1 December 2017

RMS Reference: SYD16/00261 (A20074130)
DP&E Ref: SSD 7503

EXHIBITION OF EIS ULTIMO PUBLIC SCHOOL, 47-53 JONES STREET, ULTIMO (SSD 7503)

Figure 20: Proposed vehicle access point, with Swept path of 9.5metre City of Sydney Garbage Truck entering / exiting the site

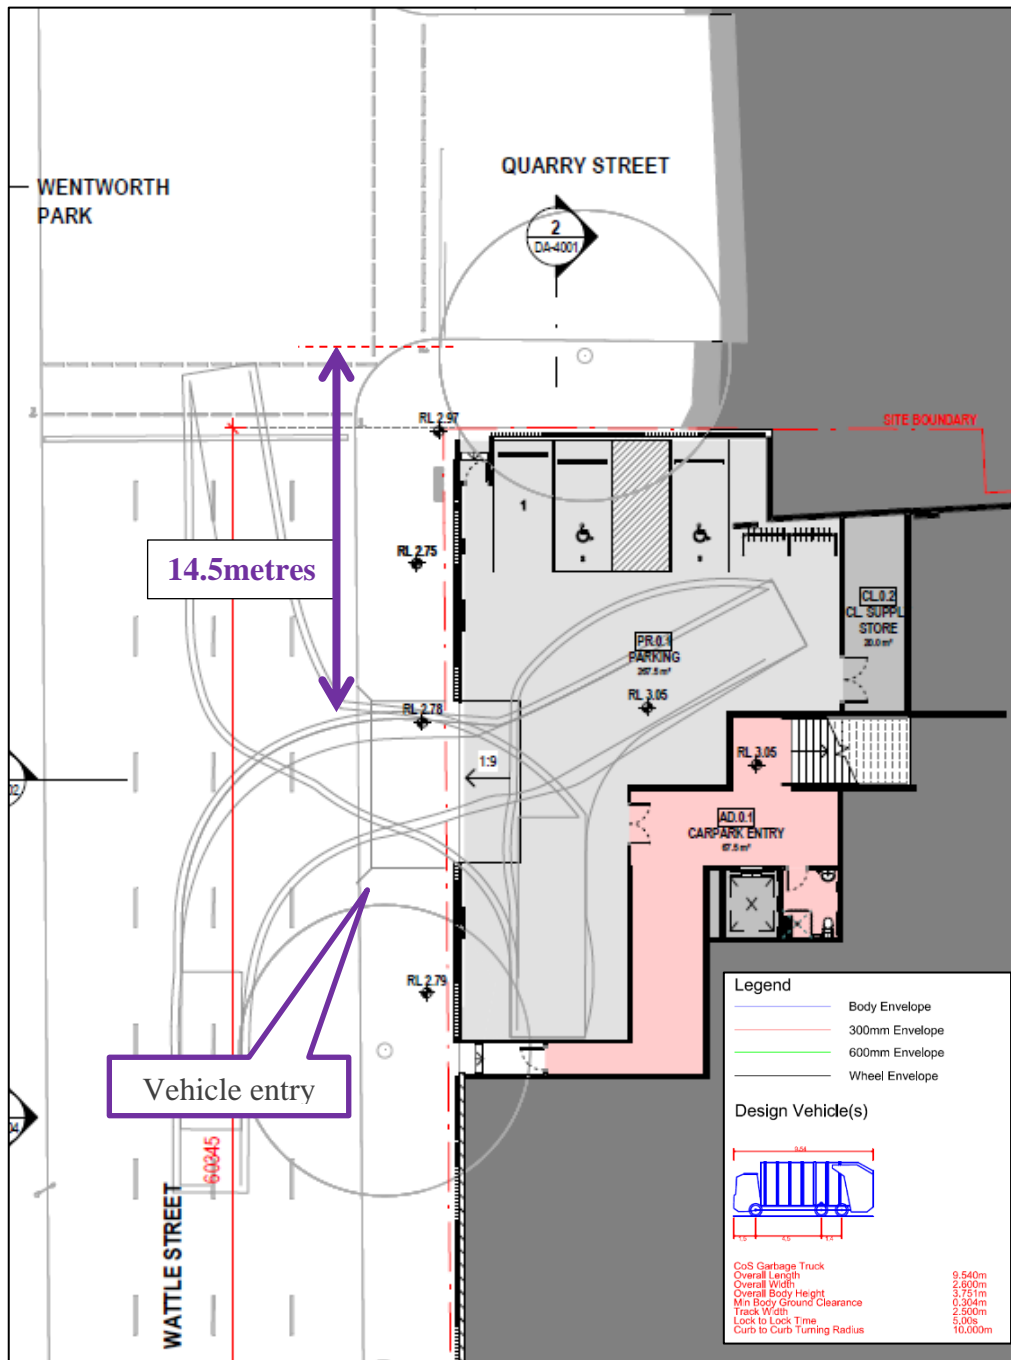
3. The swept path of the longest vehicle (including garbage trucks, maintenance and delivery vehicles) entering and exiting the subject site, as well as manoeuvrability through the site to loading areas, is to be in accordance with Austroads requirements. The swept path diagrams provided with the Transport Assessment show that service vehicles would straddle lanes 2

and 3 on Wattle Street to turn into the property. Roads and Maritime requires that vehicles turn into the property from kerbside lanes (ie lane 4 & 3).

Given this, Roads and Maritime requires amended swept path and access design plans to be submitted, prior to the determination of the application, to demonstrate that the service vehicles are able to turn from the eastern kerbside lanes only, without encroachment into other traffic lanes.

Roads and Maritime cannot provide its concurrence to the proposed driveway on Wattle Street based on the information provided. The amended plans and swept path plans to address the above issue at point 3 should be provided as part of the Response to Submissions.

Figure 24: Extended No Stopping controls on Wattle Street

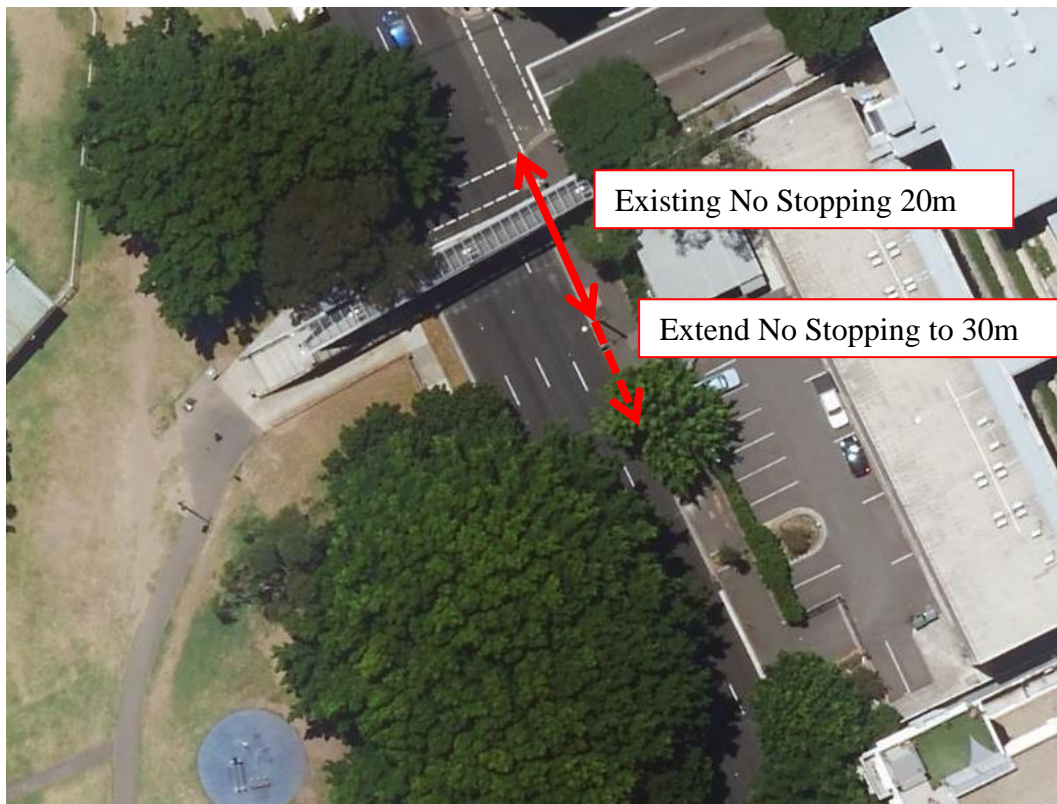
6. The No Stopping restrictions on Wattle Street will need to be extended, at no cost to Roads and Maritime, as identified in Section 3.5.4 of the Transport Assessment.
